Item No. **Report of the Head of Planning, Sport and Green Spaces**

Address 9 BARNHILL ROAD HAYES

Development: Single storey front extension involving conversion of attached garage to habitable use involving alterations to front elevation

LBH Ref Nos: **38609/APP/2015/270**

PROPOSED PLAN - GROUND FLOOR
(SCALE 1:100)

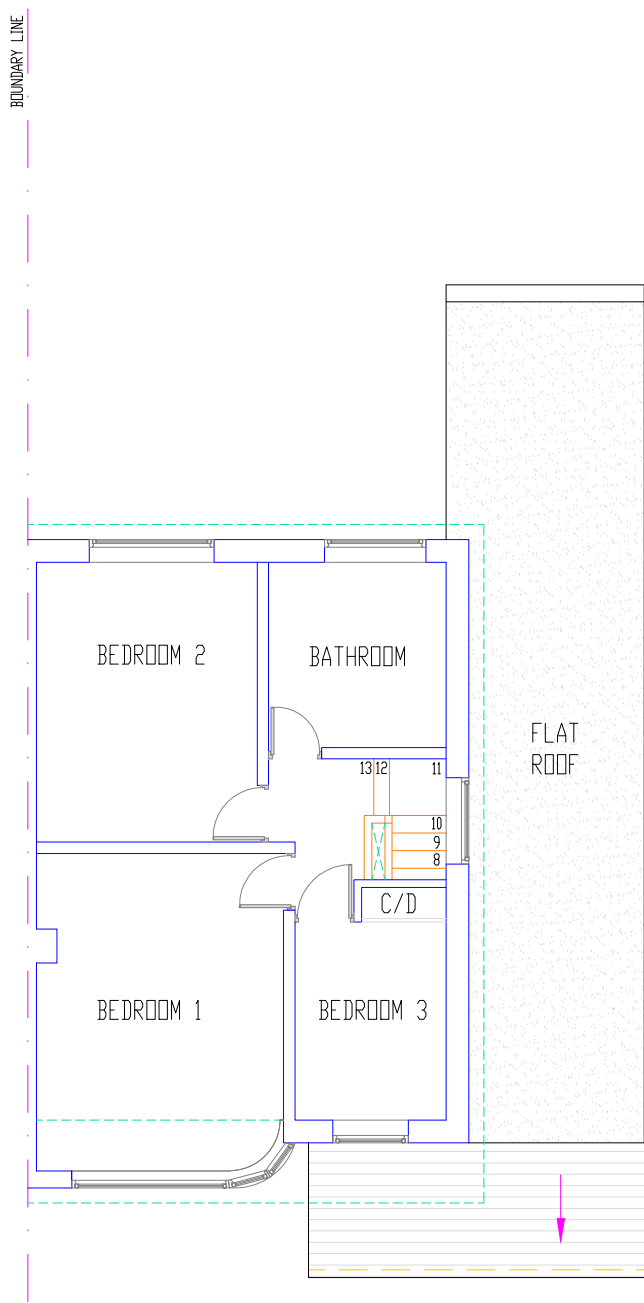
The application is seeking planning permission for the erection of a single storey front extension and to convert the existing attached garage to habitable use. The proposal would create an enlarged front porch and a new habitable room with en-suite.

The front extension would be positioned between the bay window and the flank wall and would be located to the front of the existing porch and garage. It would project from the existing front building line 1.086 metres and would have a width of 4.553 metres. The extension would be characterised by a mono pitched roof and would have a maximum height of 3.4 metres and would be the same height as the existing porch and front extension.

The proposed garage conversion would involve the loss of an existing garage. However, the garage measures 2.35 metres wide by 5.4 metres deep and so does not meet the Council's required standards (Annex 1, Hillingdon Local Plan: Part Two - Saved UDP Policies (November 2012)). The proposal would create a small reduction of hardstanding to the front of the property. However, following development there would be over 9 metres of hardstanding available for up to three off street parking spaces to be situated within the curtilage of the site. As such, the proposal would not result in an increase in on-street demand for parking and so would be in accordance with Policy AM7 and AM14 of the Hillingdon Local Plan: Part Two - Saved UDP Policies (November 2012), the Council's Parking Standards (Annex 1, Hillingdon Local Plan: Part Two - Saved UDP Policies (November 2012)) and Policy 6.13 of the London Plan (2011).

PROPOSED ELEVATION - FRONT (UNCHANGED)
(SCALE 1:100)

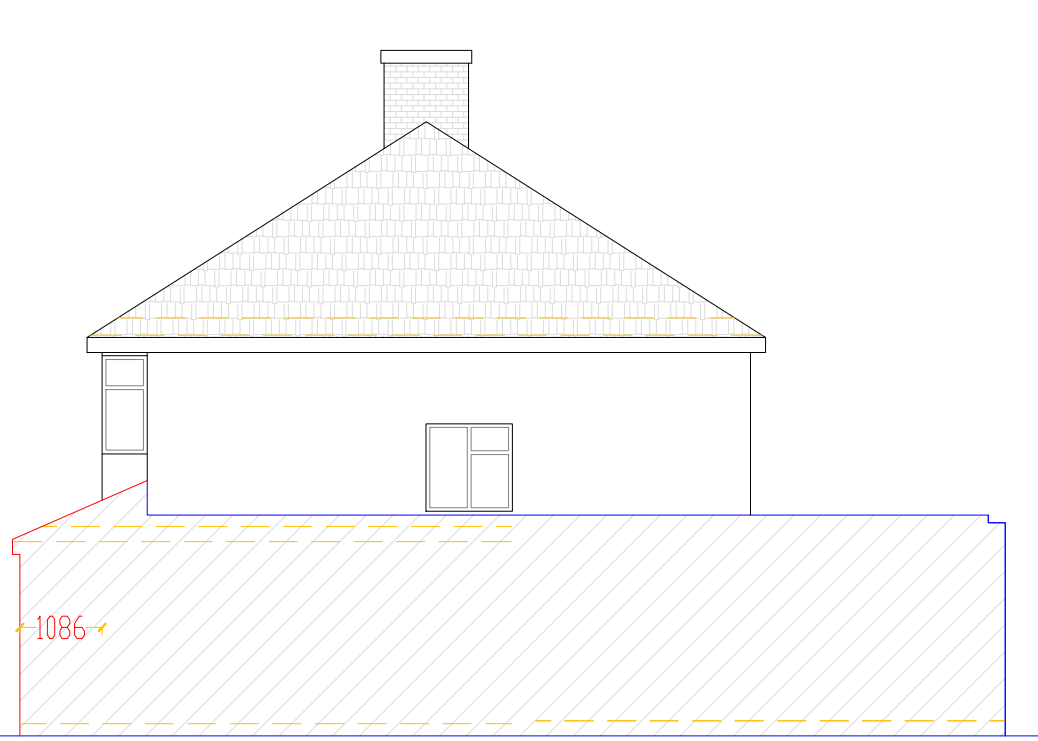
Section 8 of the Hillingdon Design and Accessibility Statement: Residential Extensions (HDAS) states that the Council is very explicit with regard to its position on front extensions. A front extension that extends across the entire frontage will normally be refused. Front extensions are eye catching and change the face of the building impacting the character and appearance of both the building and the street scene. The proposed extension would have a height of 3.4 metres, matching the height of the existing porch and it would have a width of 4.553 metres which would be just over half of the width of the existing dwelling. The fenestration would be of a similar style to the existing. However, the proposal would create an extension would have a depth 1.686 metres from the original front building line and a depth of 1.086 metres from the existing bay window. Therefore, it is considered that the size, scale and forward projection would form an overly dominant and incongruous development that would detract from the character of the existing property and visual amenity of the surrounding area. Therefore, the proposal would not comply with Policies BE13, BE15 and BE19 of the Hillingdon Local Plan: Part Two - Saved UDP Policies (November 2012).

The proposed extension, by virtue of its size, scale, bulk and projection forward of the principal elevation would result in an incongruous and overly dominant addition which would be detrimental to the architectural composition of the existing building, the visual amenities of the street scene and would harm the character and appearance of the wider area. The proposal would therefore be contrary to Policy BE1 of the Hillingdon Local Plan: Part One - Strategic Policies (November 2012), Policies BE13, BE15 and BE19 of the Hillingdon Local Plan: Part Two - UDP Saved Policies (November 2012) and the adopted Supplementary Planning Document HDAS: Residential Extensions.

PROPOSED SITE PLAN
(SCALE 1:500)

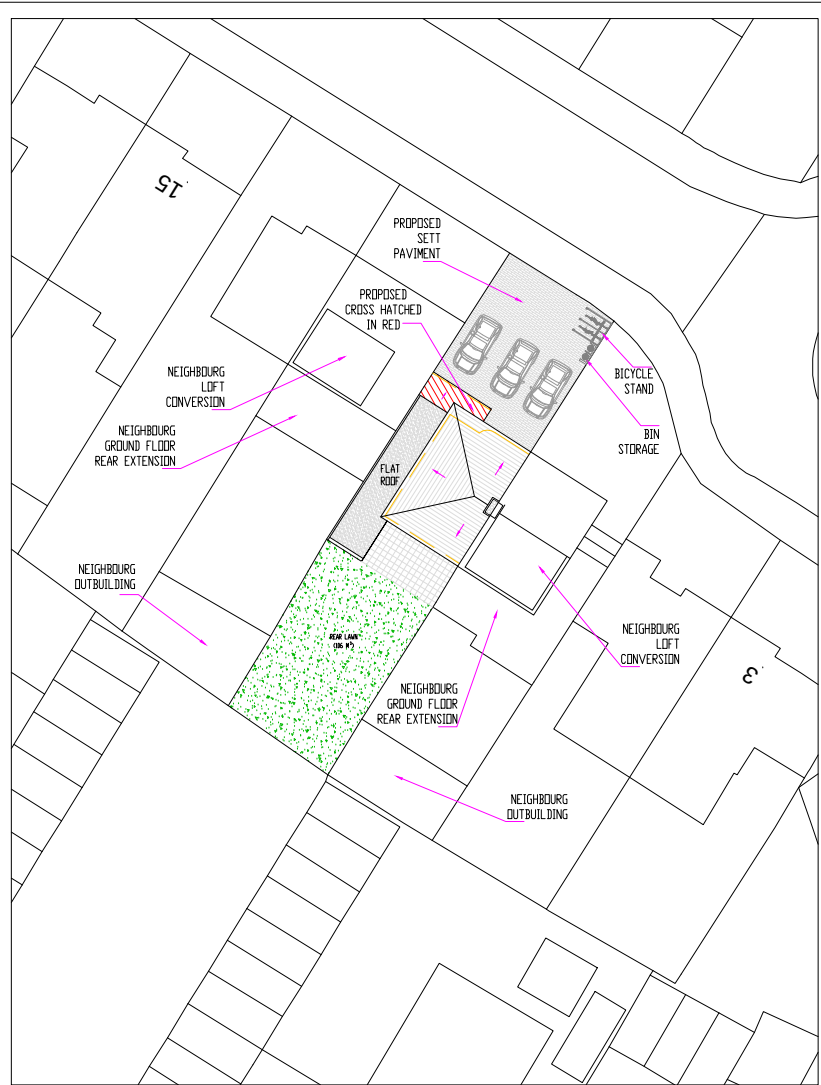
The proposed extension would be built up to the flank wall of No.11 Barnhill Road, however it would be set back approximately 3.7 metres from the front building line of this neighbouring property. The extension would be situated 3.7 metres from the boundary line of No.7 Barnhill Road. The proposed fenestration would be located to the front and would not overlook any properties significantly more than already exists. Therefore, it is considered that the distance between the proposed development and neighbouring

properties would not cause any significant impact on the residential amenity of the neighbouring property in terms of loss of light, loss of outlook or overshadowing. As such, the proposal would comply with Policies BE20, BE21 and BE24 of the Hillingdon Local Plan: Part Two - Saved UDP Policies (November 2012).
